From: Simon Davis
Sent: 19 February 2021 17:44
To: 'Tilly Whishaw' [REDACTED]
Subject: RE: Y/146/20/RES - Land at Street Buildings, North End Road, Yapton

Simon J Davis MRTPI
Principal Planning Officer
Directorate of Place

Title:
PLANNING LAYOUT

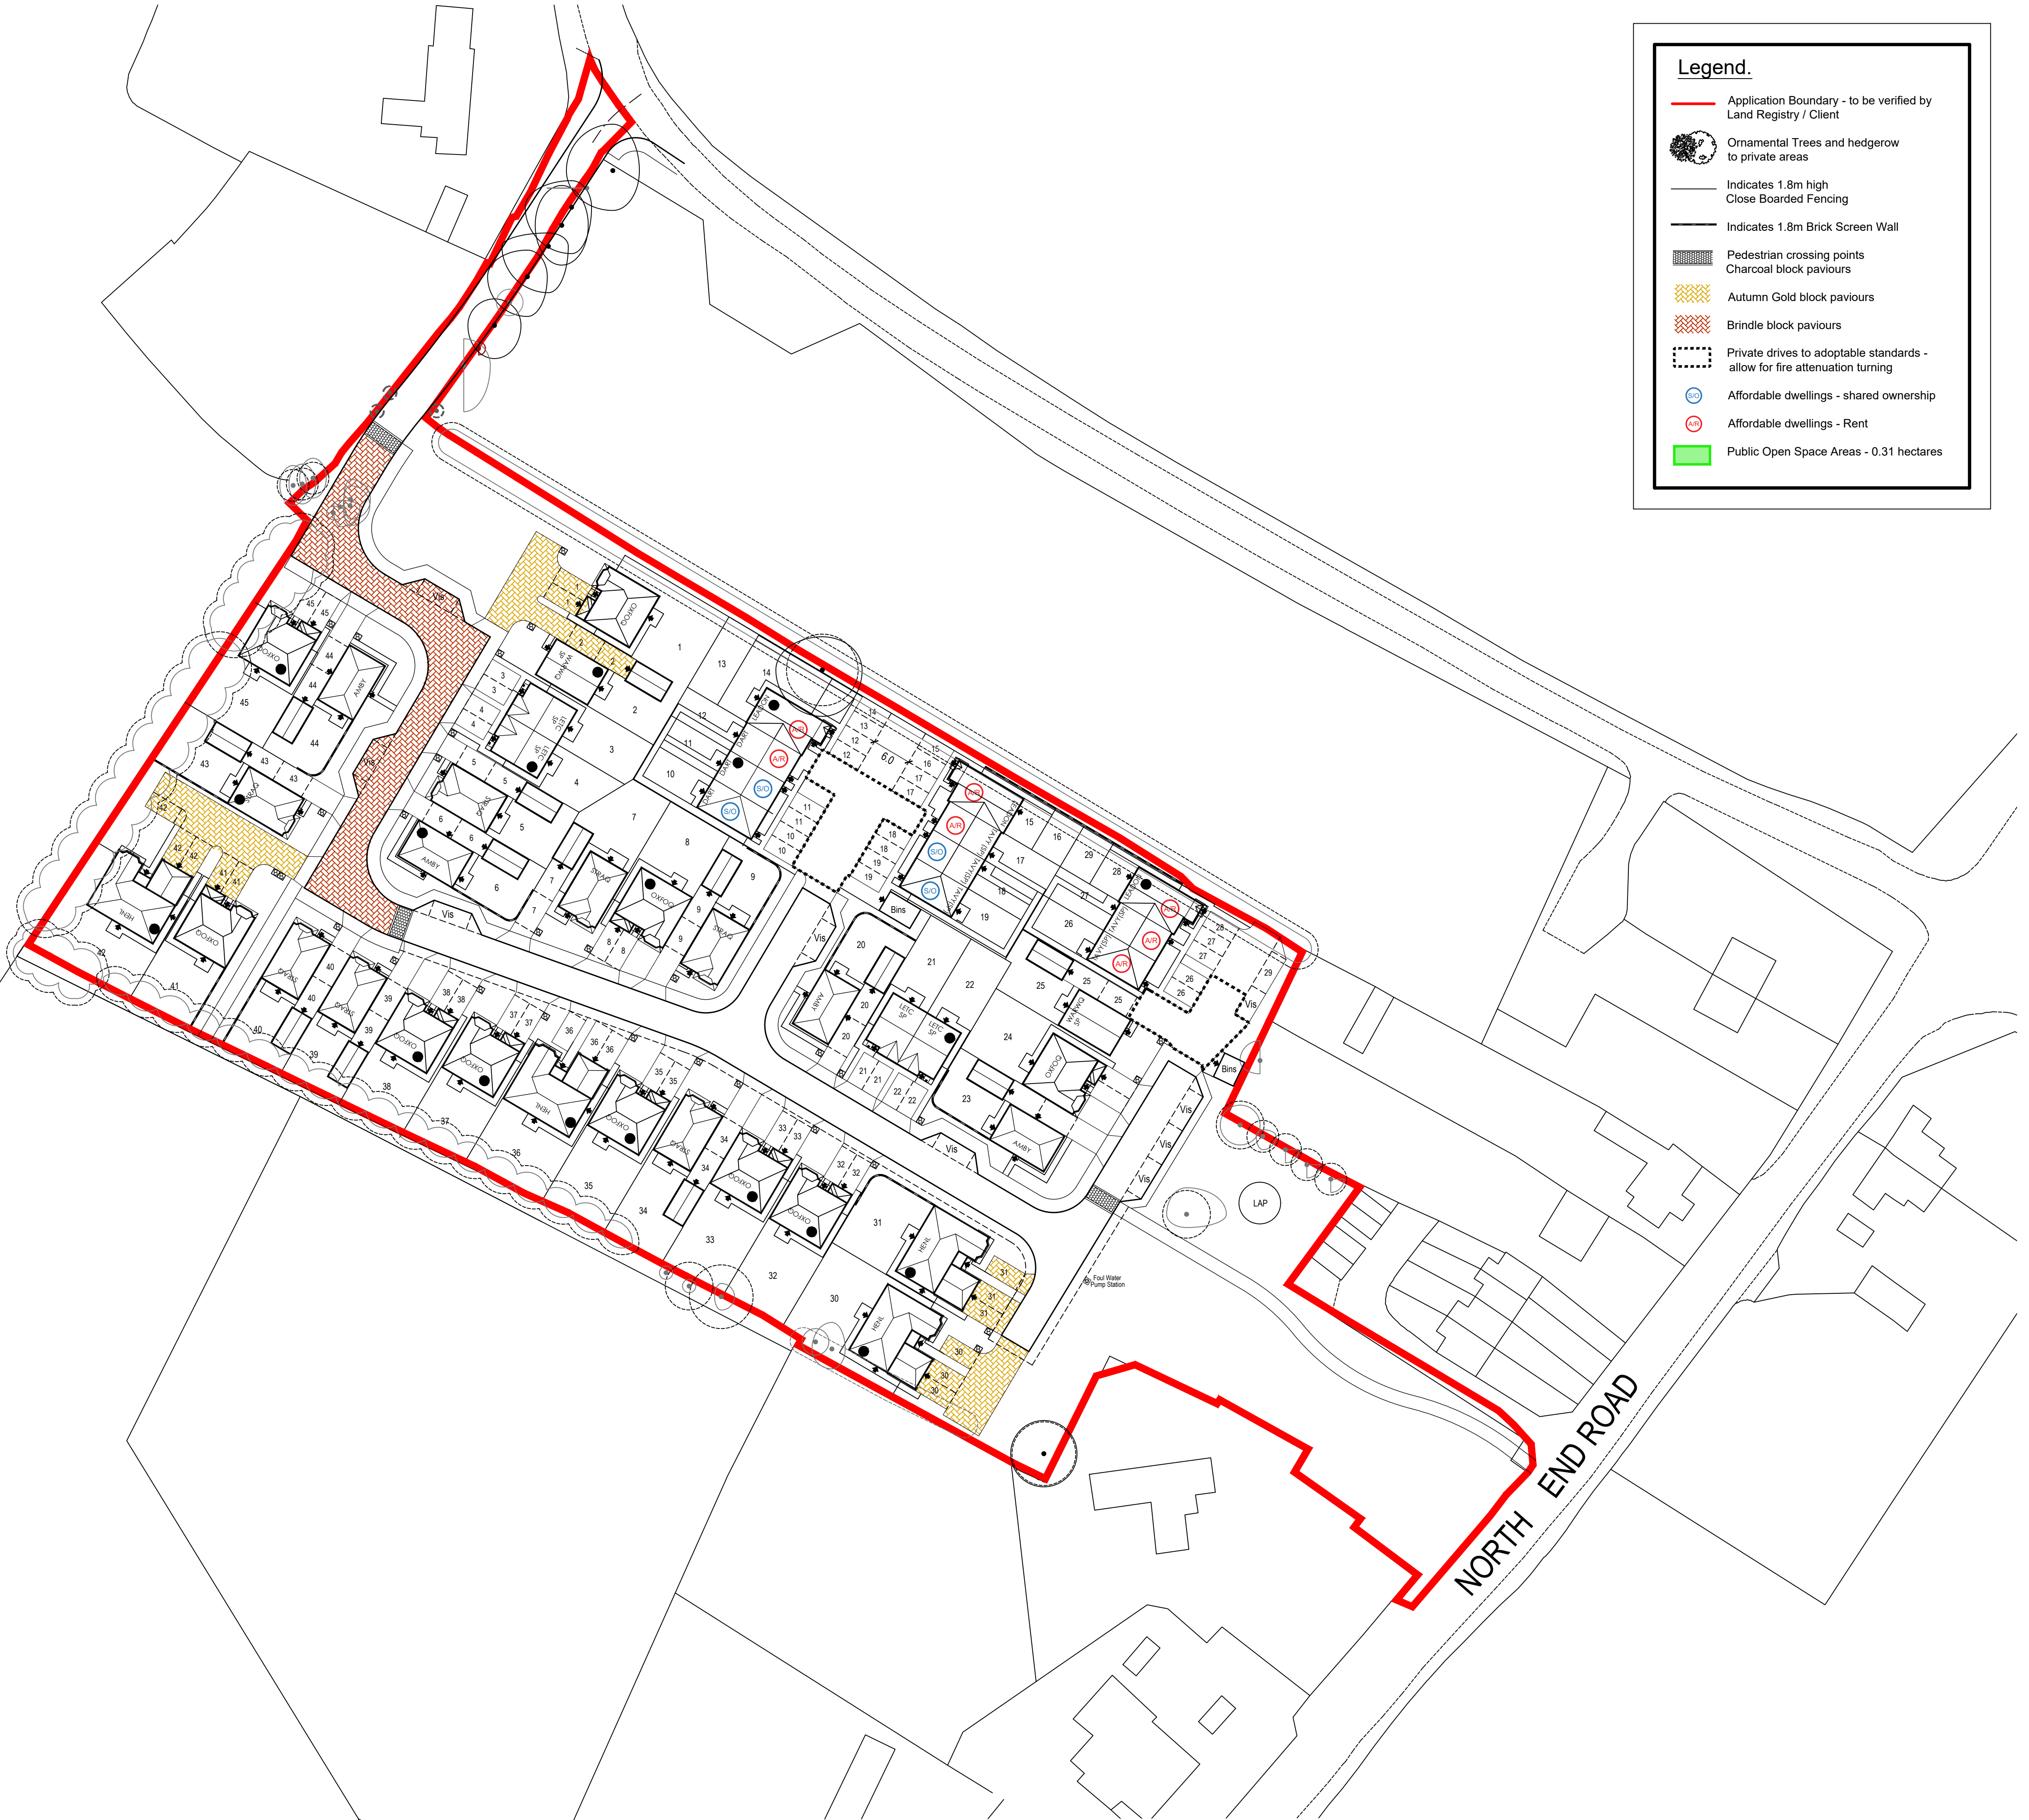
The increase in length of the Tavy does appear to eat into the depth of the rear garden (unless the extra 0.3m is to the front?)

If it is into the rear garden then I consider the following garden depths to be short versus the Design Guide:

18/19 - 9.2m long
26 - 9.5m long

However, there is not a significant difference versus the approved scheme so I feel capable of supporting the change.

Title:
TAVY - LEADON
PLANS

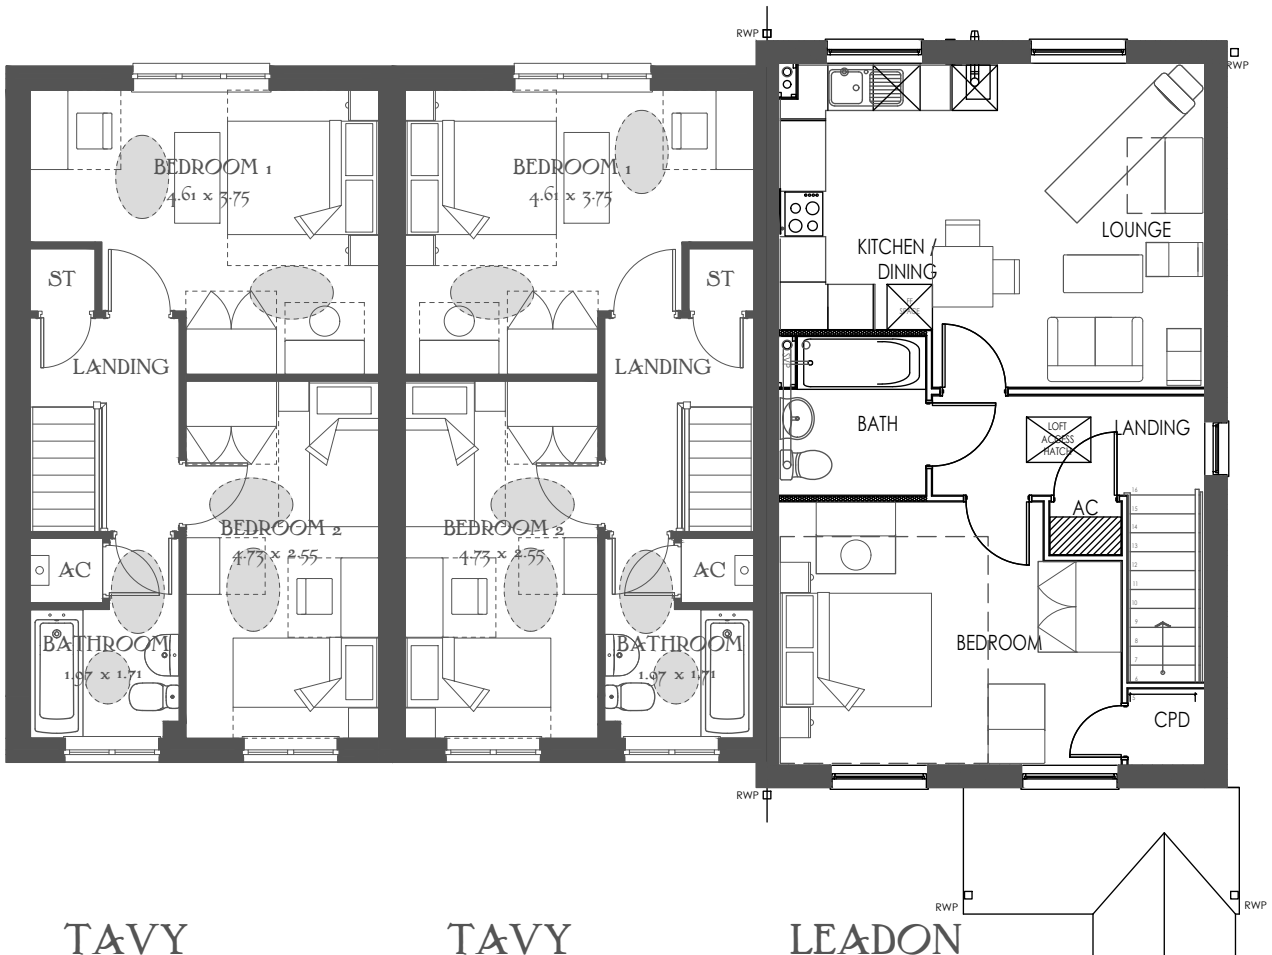
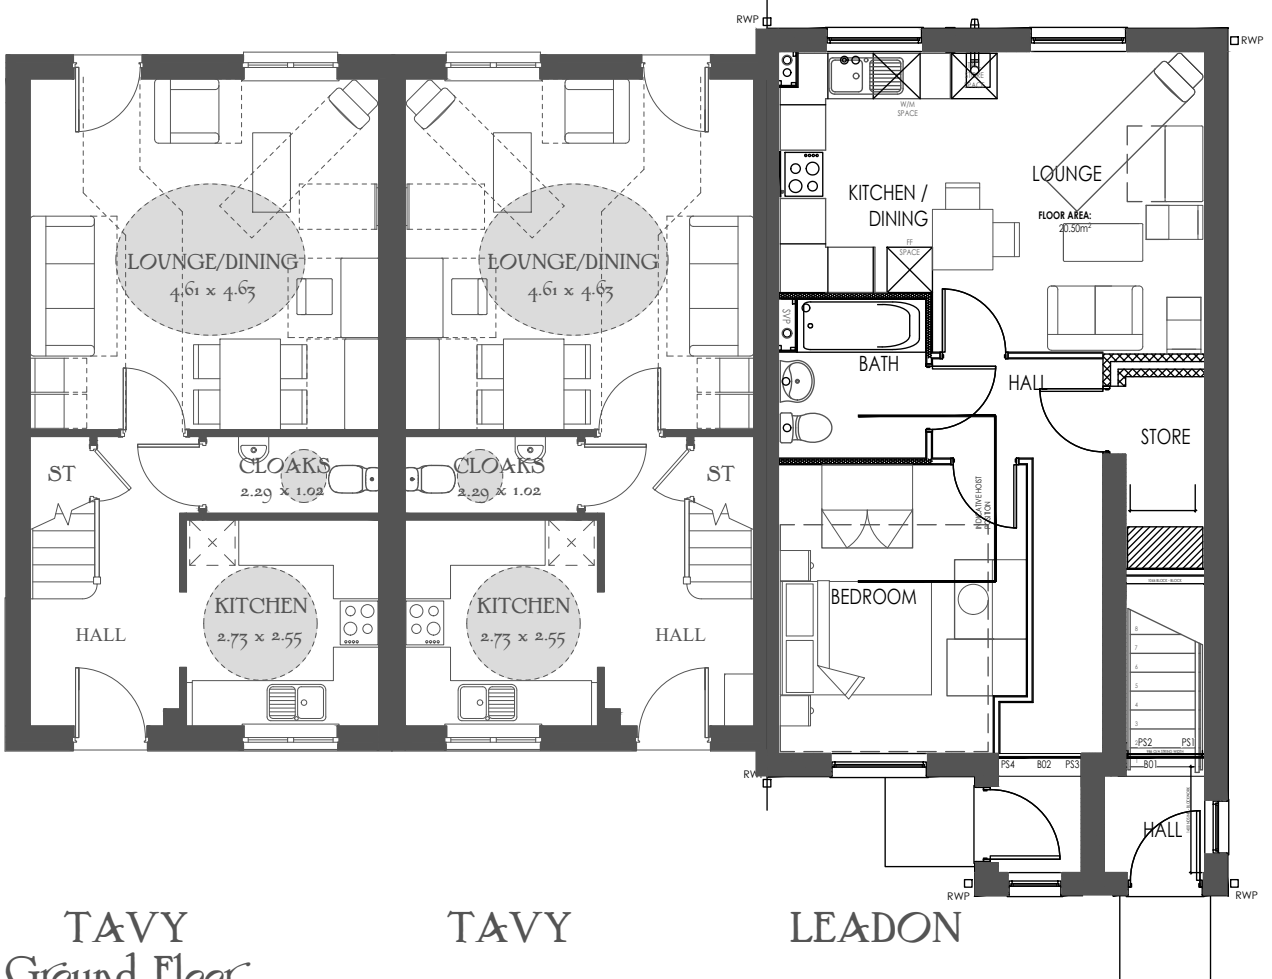
Please can you also confirm the changes in dimensions for the Tavy House types. It appears to me that the Tavy is now around 0.3m longer than before with a similar width. However, the ratio of Tavy length vs Leadon length remains the same so has the Leadon also increased in length? Please advise.

The proposed Tavy is 0.3m longer than the approved and is the same width.

Title:
TIMBER BIN STORE
PLOTS 26-29
ELEVATION / SECTION

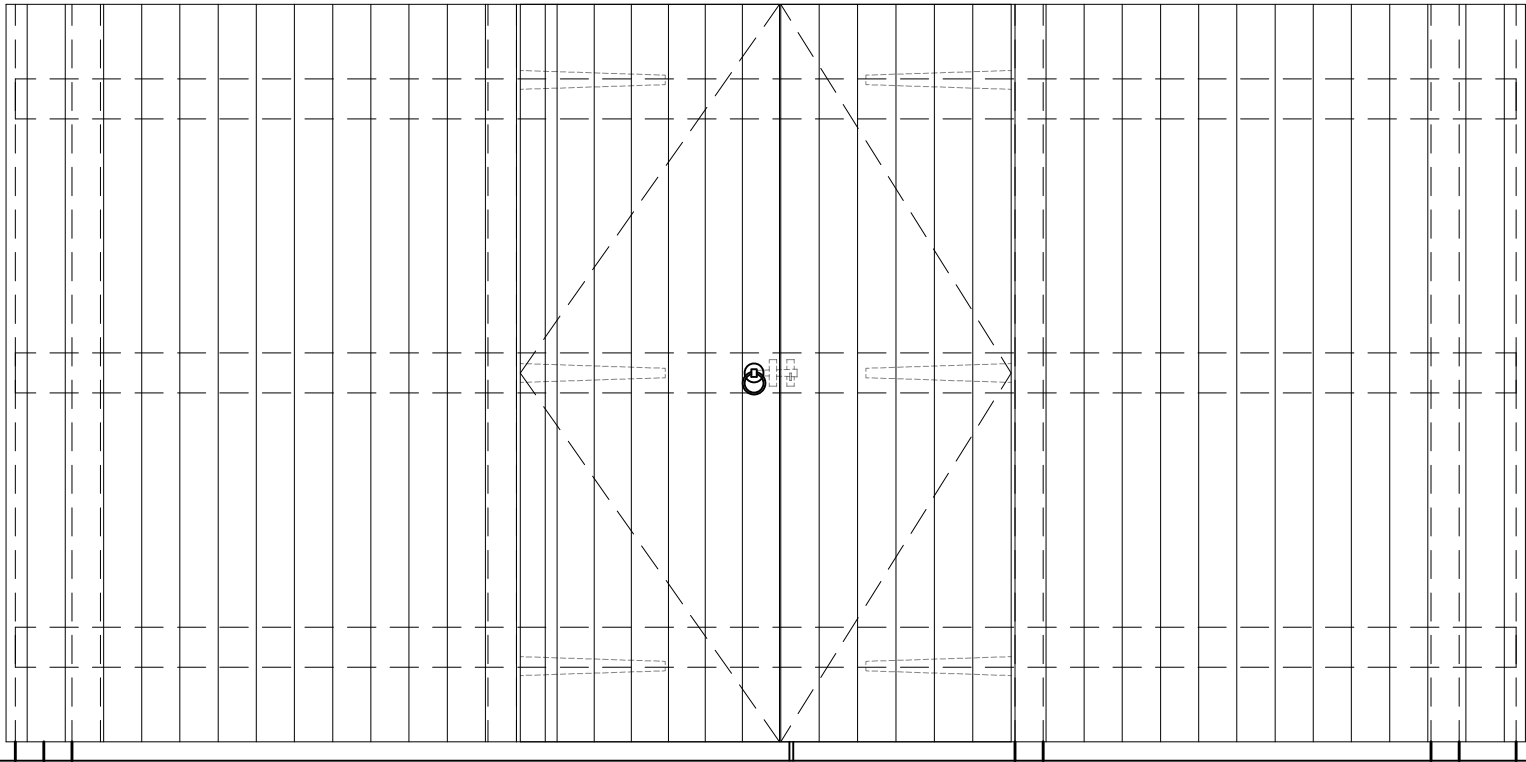
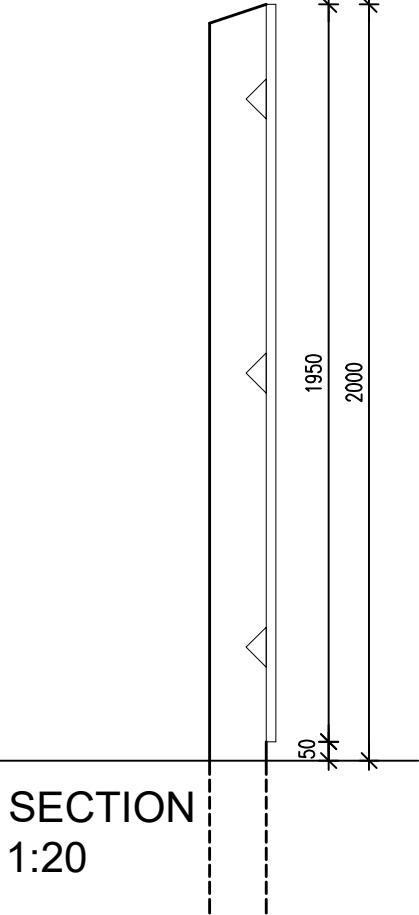
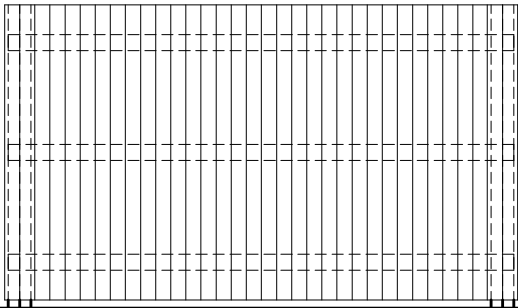
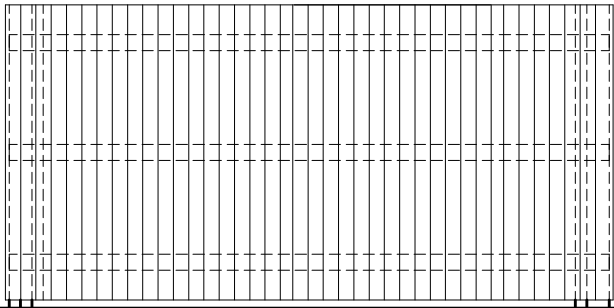
The only change in addition to my email from 17th December 2020 is that the bin store buildings have been replaced with close board fencing enclosures in the same location. Details of this are included in the submitted house type brochure.
